The Coal
Authority

Re: Planning application 2025/62/93355/E

Erection of 75 residential dwellings with associated landscaping, open space, highways and drainage infrastructure at Land off Woodward Court, Mirfield, WF14 OPY - RECONSULTATION

The Coal Authority response: SUBSTANTIVE CONCERN

SCALE	1:1250	SHEET	A3	DRAWING NO.	5670/20	REVISION	E
-------	--------	-------	----	-------------	---------	----------	---

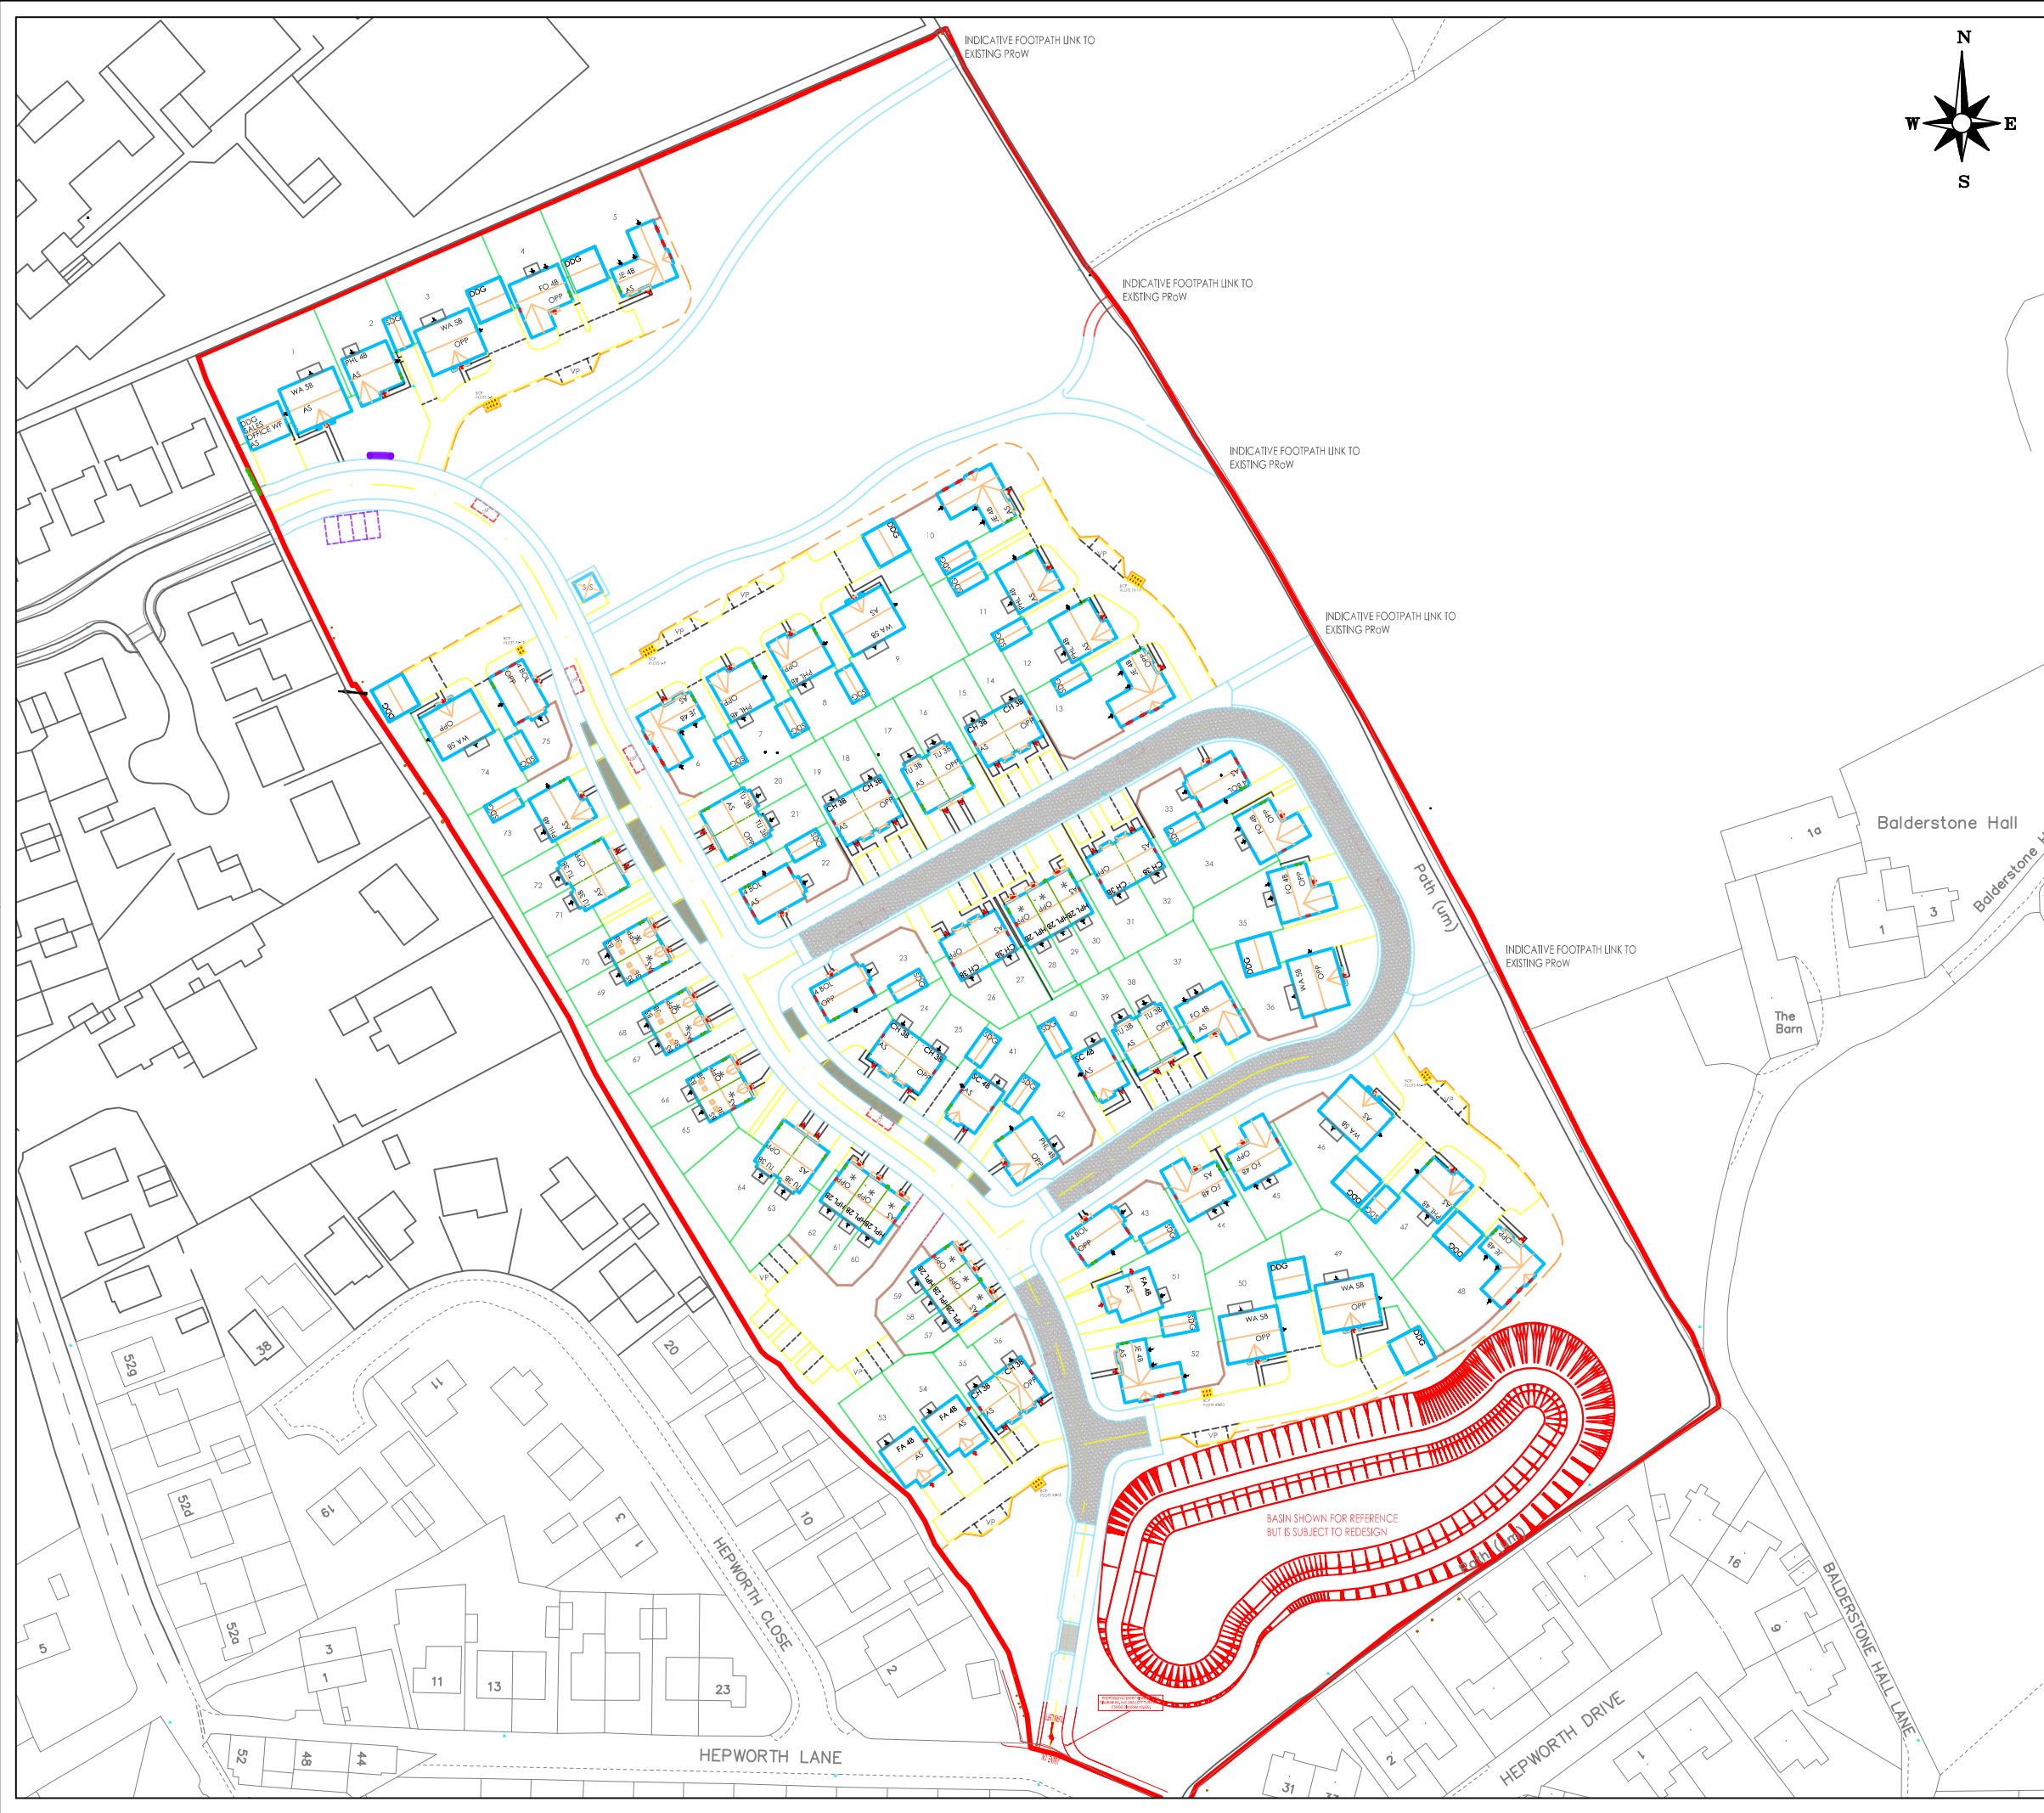
We note that Drawing nos. 5670/21 and 5670/22 included in Appendix A of the specification document show the previously unrecorded mine entries/features and the their zones of influence / no build zones (as calculated in the Geoenvironmental Appraisal) in the context of the current development layout. However, it is clear there exists the potential for further mine entries to be present as the full site strip has yet to take place, as mentioned above.

With regards to the treatment of shallow mine workings, we note that the specification document indicates that proof drilling and grouting of shallow mine workings is proposed at those plots located close to the previously identified mine entries, as shown on Drawing no. 5670/21. We note that these treatment works do not extend radially away from the mine entries but will focus on the buildings close by. The specification document indicates

Given the limited treatment works, it would appear that external parts of the site, such as roads, hard surfaced parking areas, paths and gardens near to the mine entries and presumably considered to be potentially underlain by shallow mine workings will not be treated. The justification for this approach is unclear. It is also unclear why the potential for the presence of underground workings extending further from the mine entries, and therefore potentially requiring treatment, has been discounted.

- AREA OF SOIL STRIPPED IN 2018
- AREA OF SOIL STRIPPED IN 2026
- AREA OF MADE GROUND

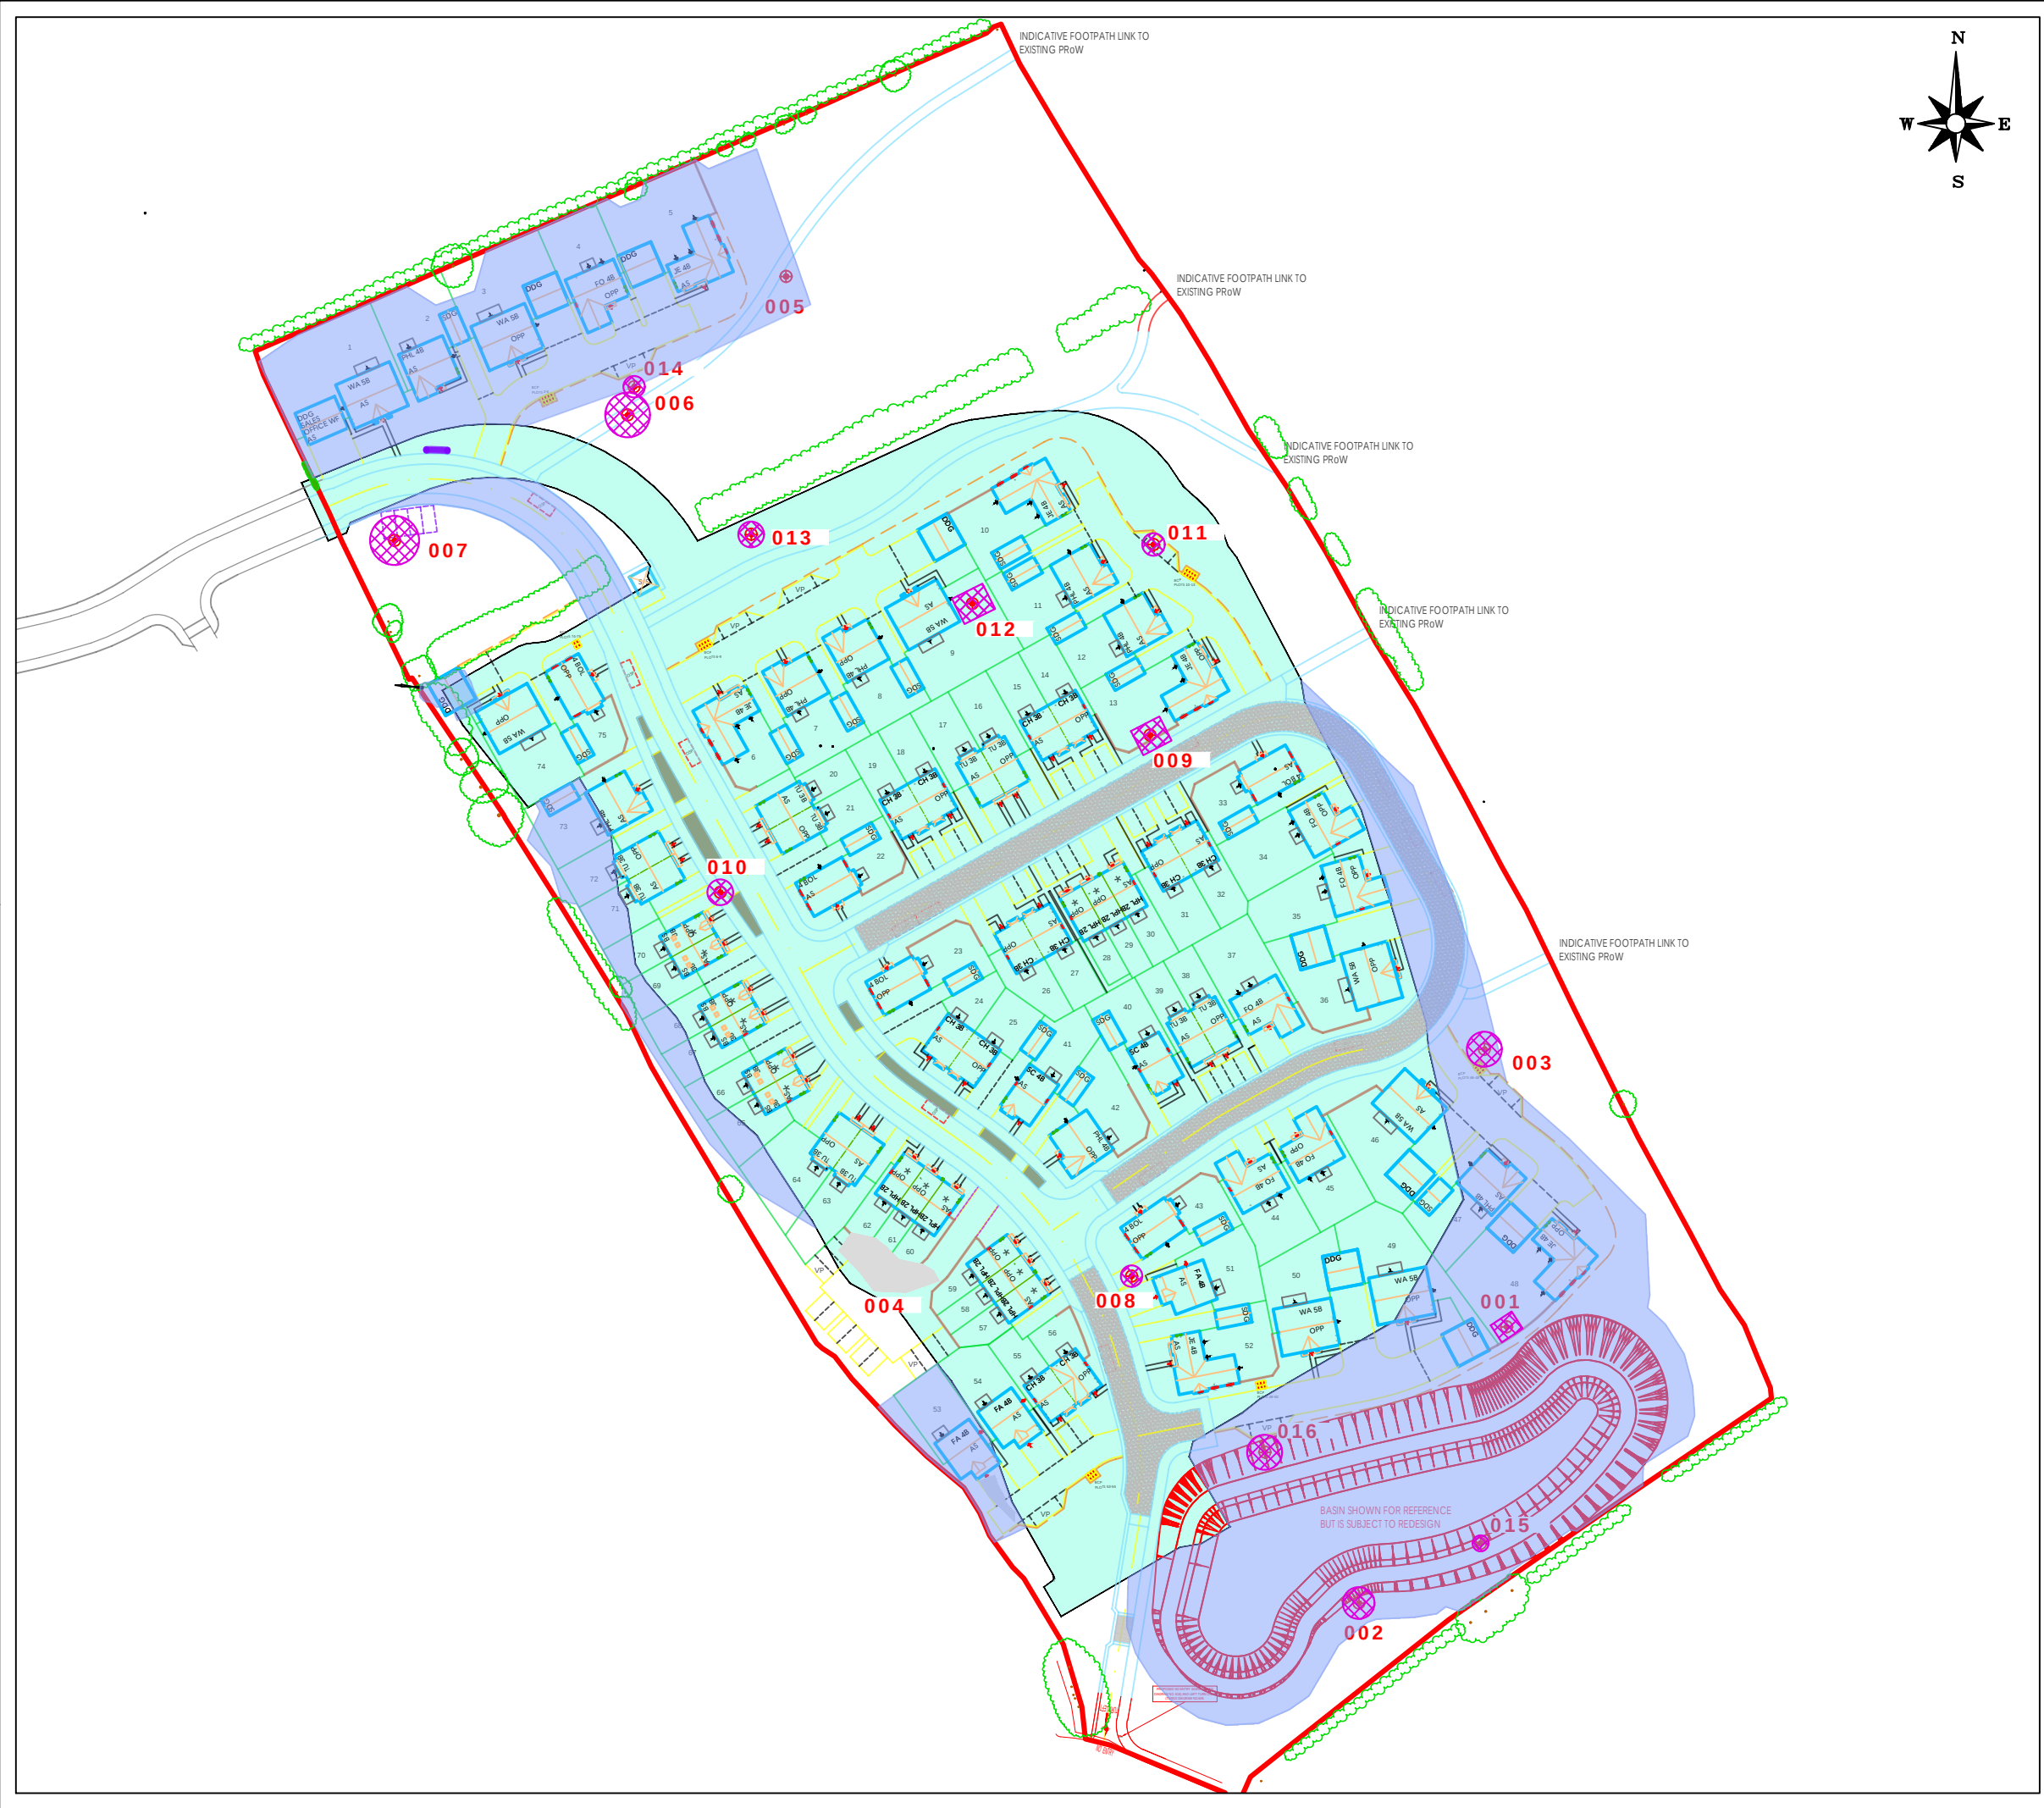
The specification states at paragraph 1.2.4 that *'a soil strip undertaken in 2018 was based on the proposed housing layout at that time which comprised 61 plots. The current layout includes more plots (75) and shows development in areas beyond that previously stripped.'* It goes on to comment at paragraph 1.2.5 that *'Prior to commencement of the works described in this Specification, Bellway will commission further soil stripping to allow examination of the exposed natural Subsoil beneath the entire footprint of the development currently proposed (including the SuDS basin).'*

In light of the above, it is evident that the matters we previously raised regarding the undertaking of further investigations in respect of the additional development areas prior to the determination of the application have not been addressed.
